March 13, 2017

Re: Restaurant and Mercantile Fit-Up, 6 City Center

Portland, Maine

Please see the answers below and attachments to address your comments.

A5-0

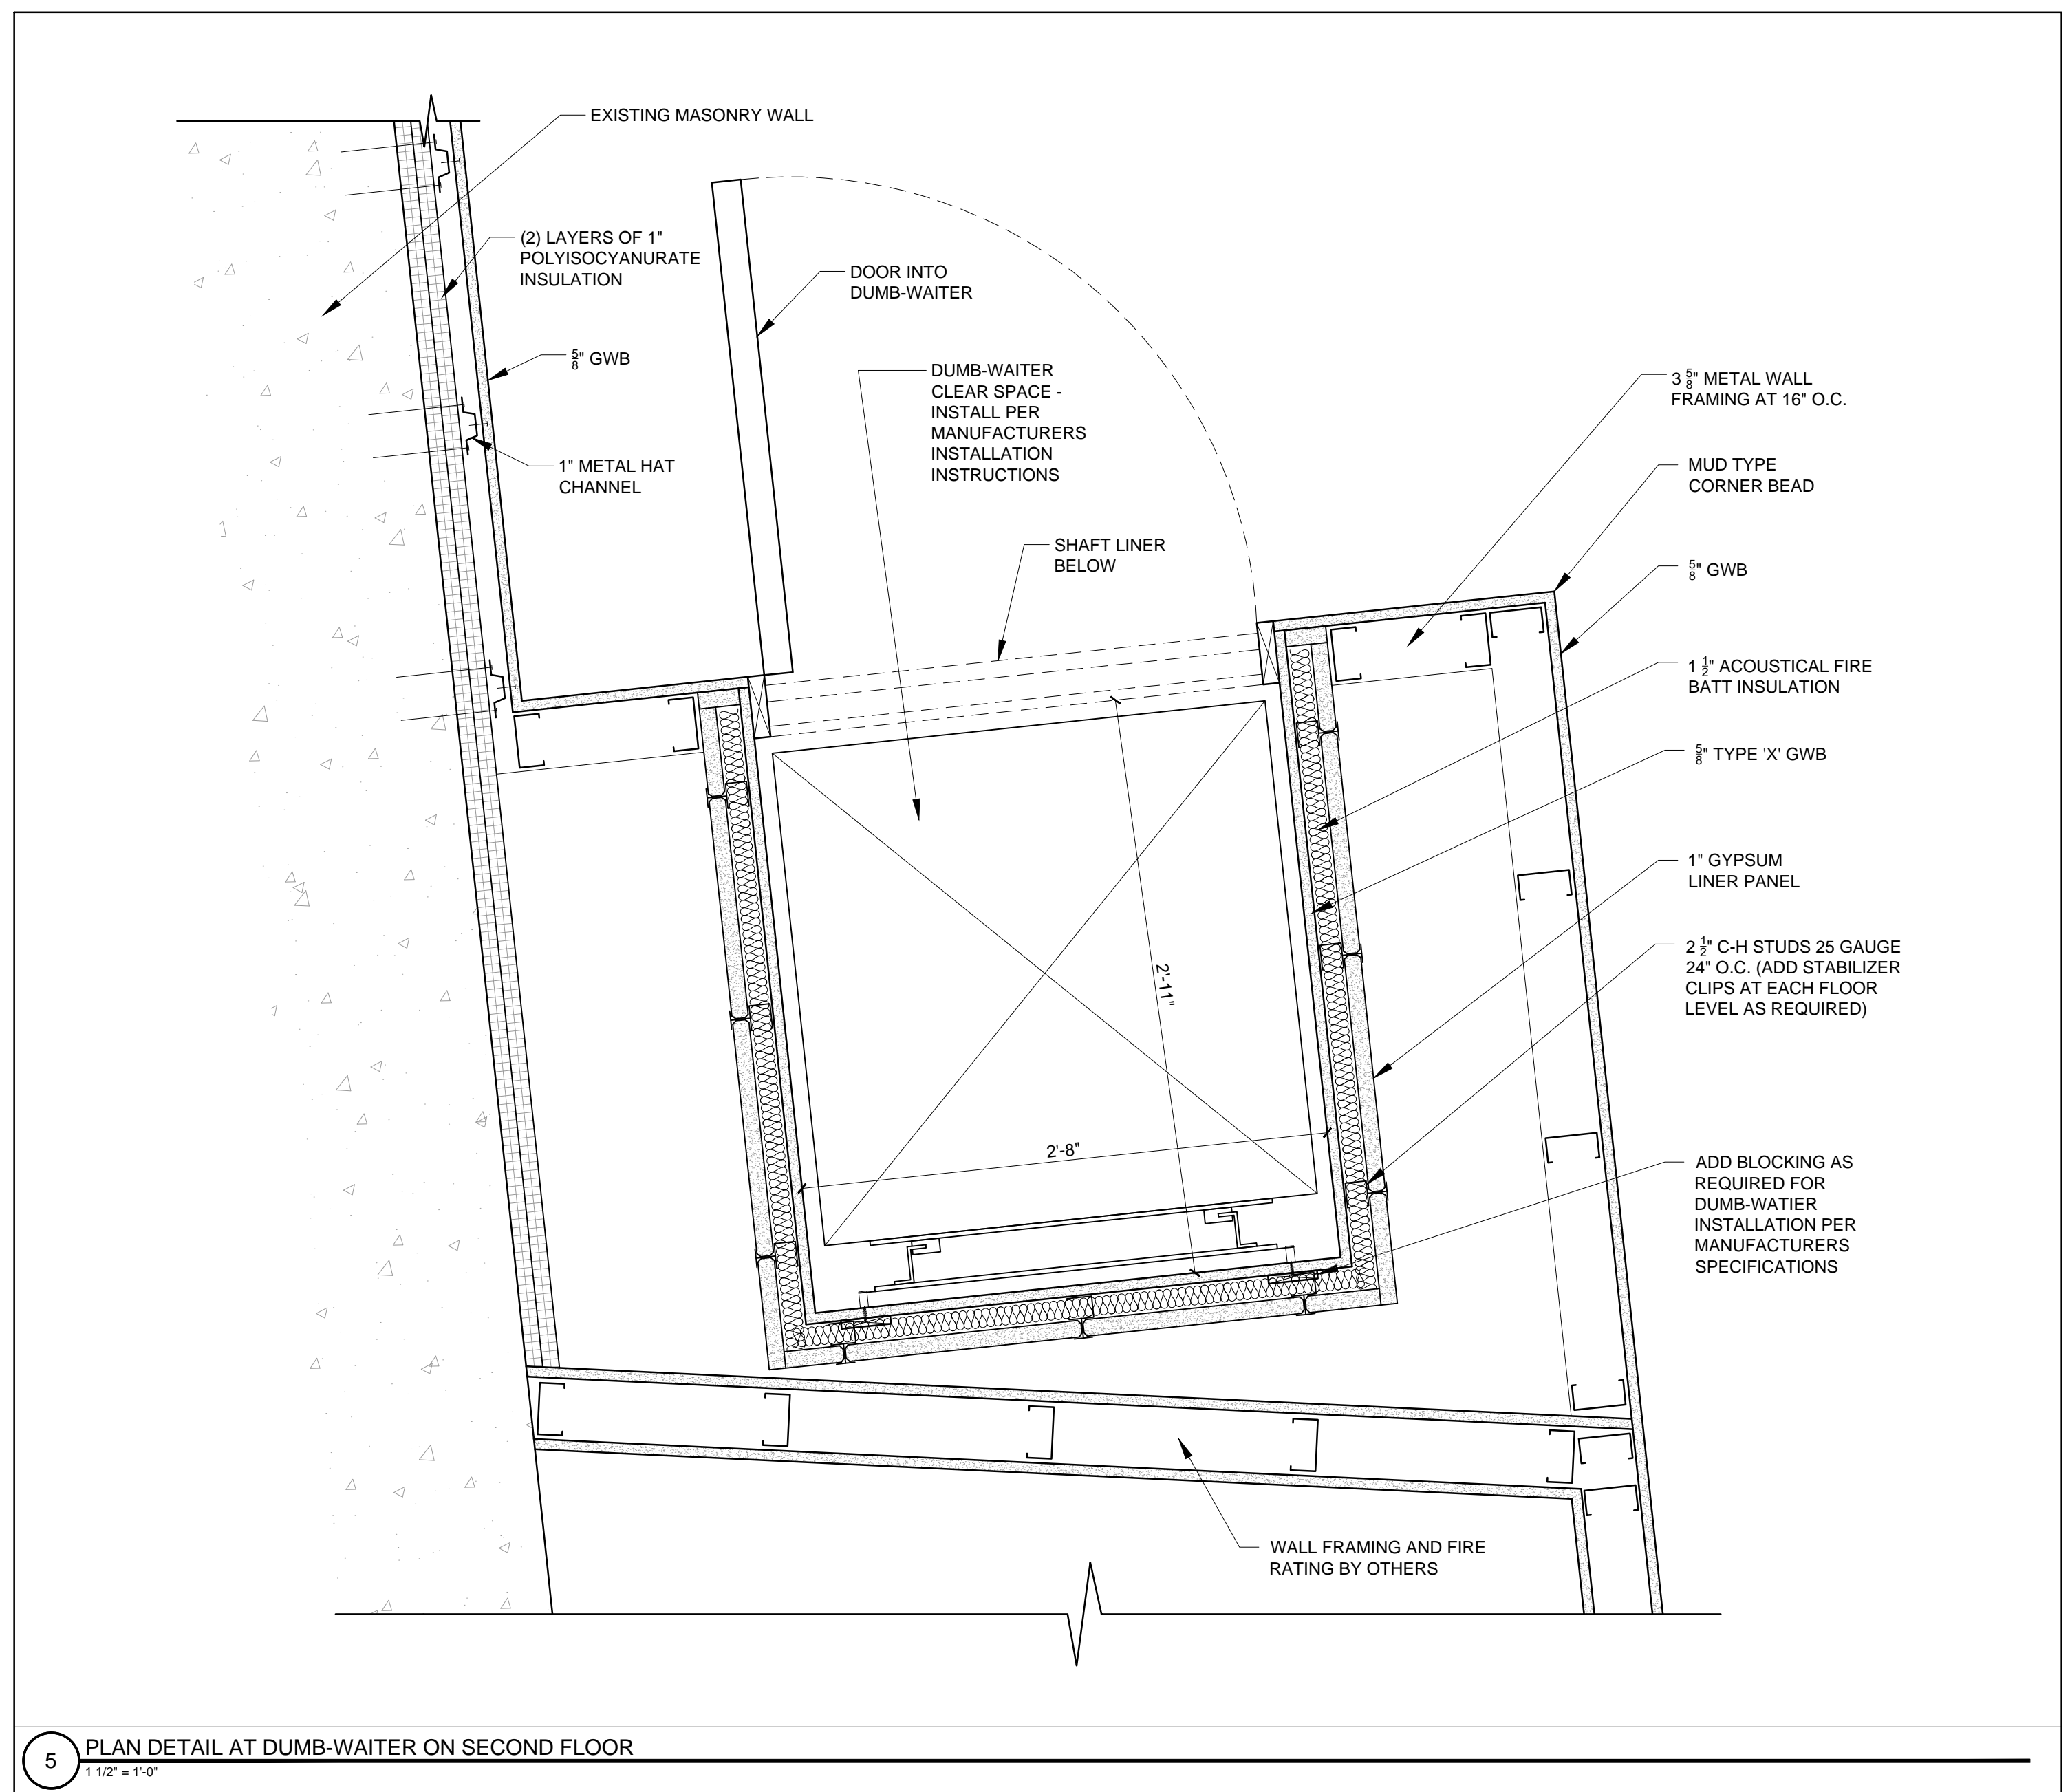
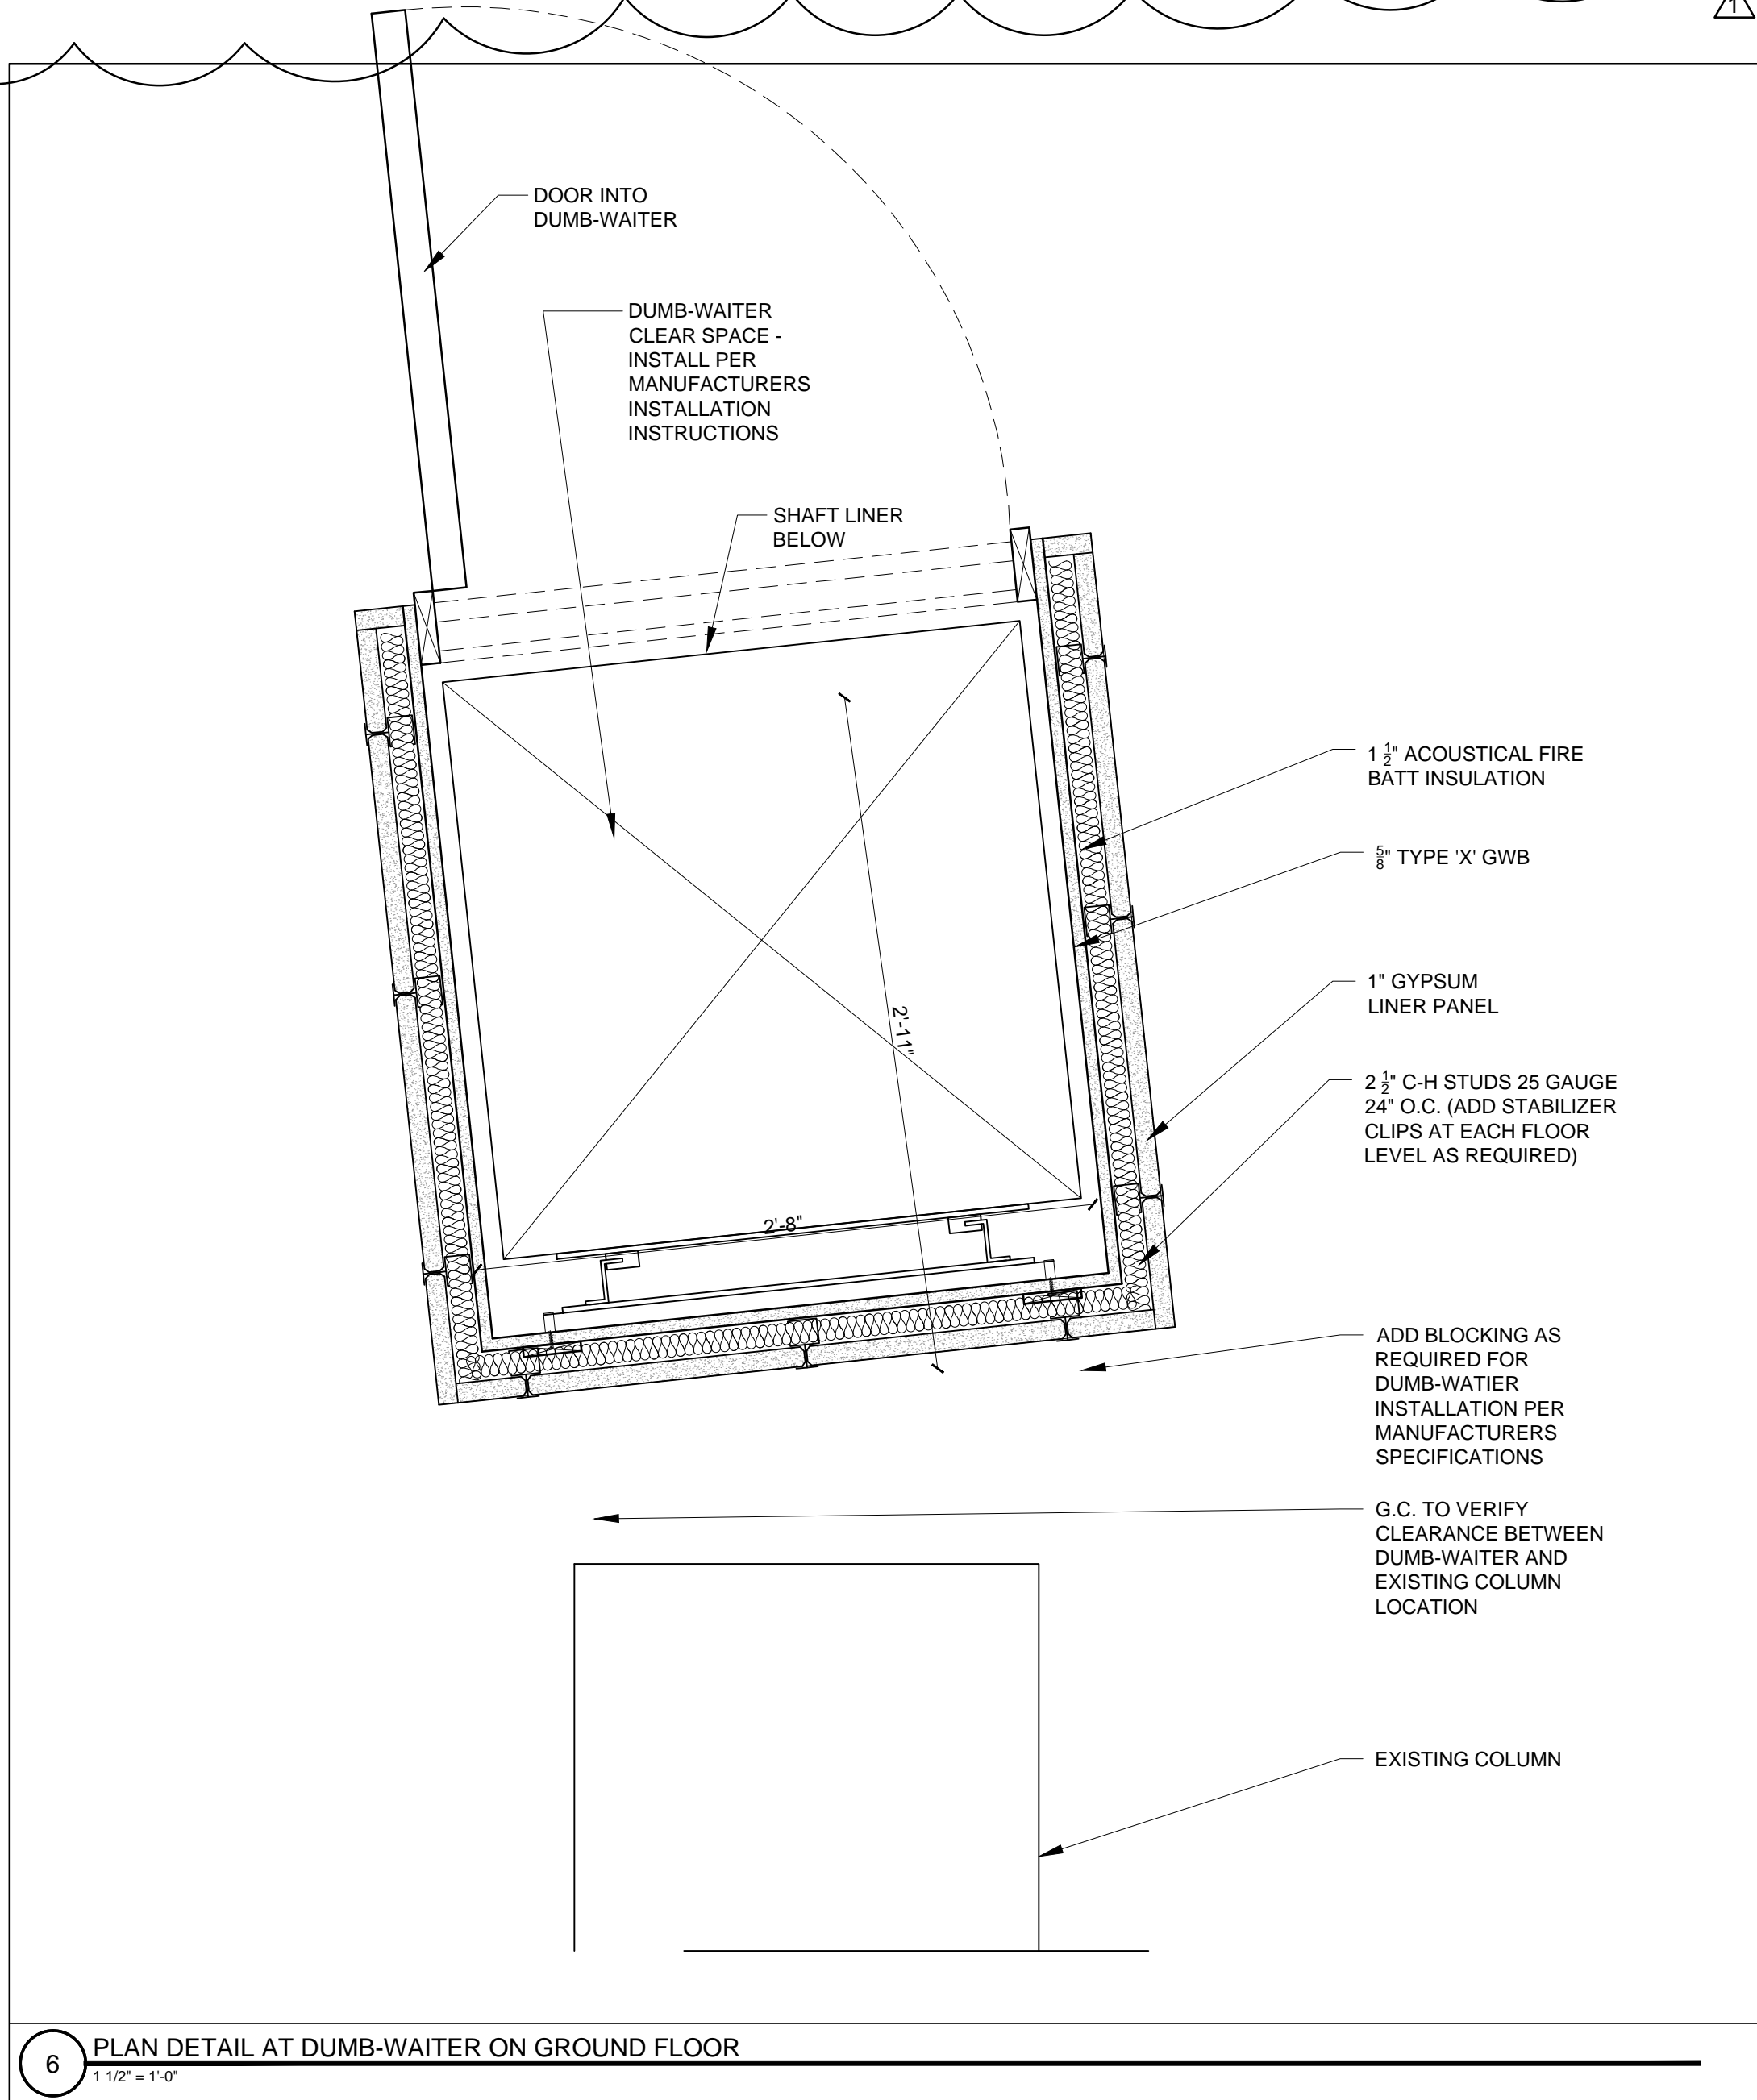
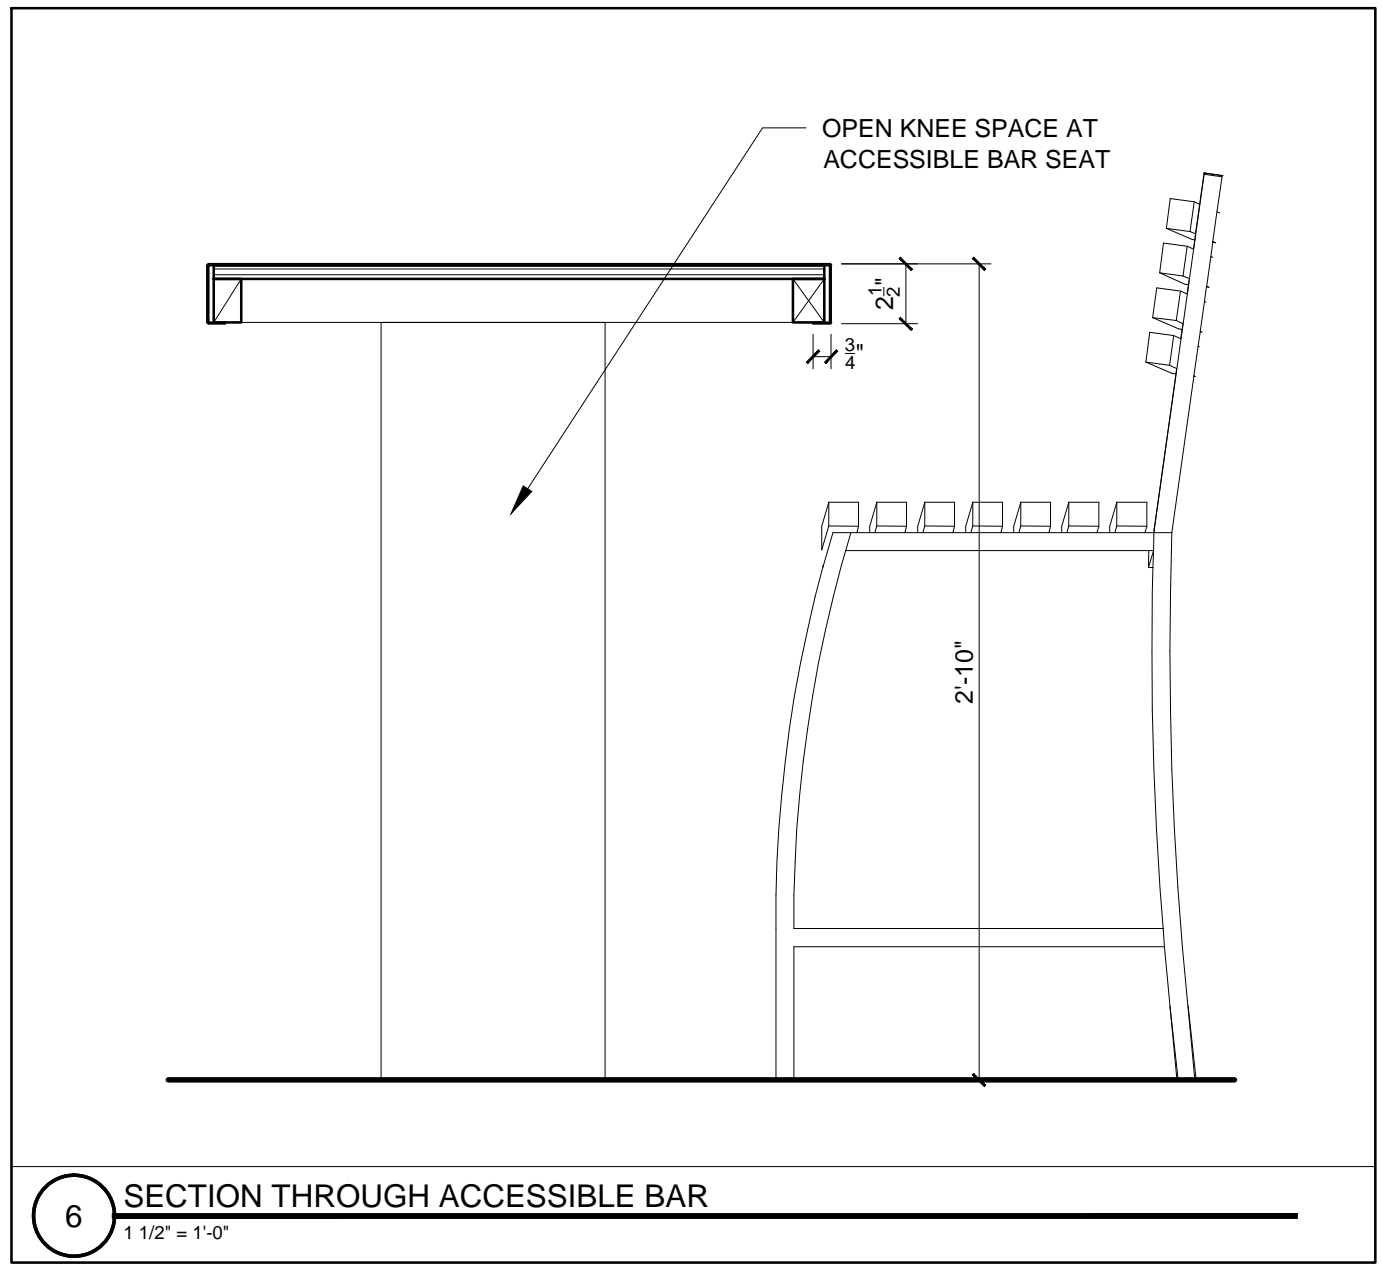
A5-0 See the attached revised drawing sheet with details 6 and 7 showing sections through the Accessible Bar and Mercantile counter area
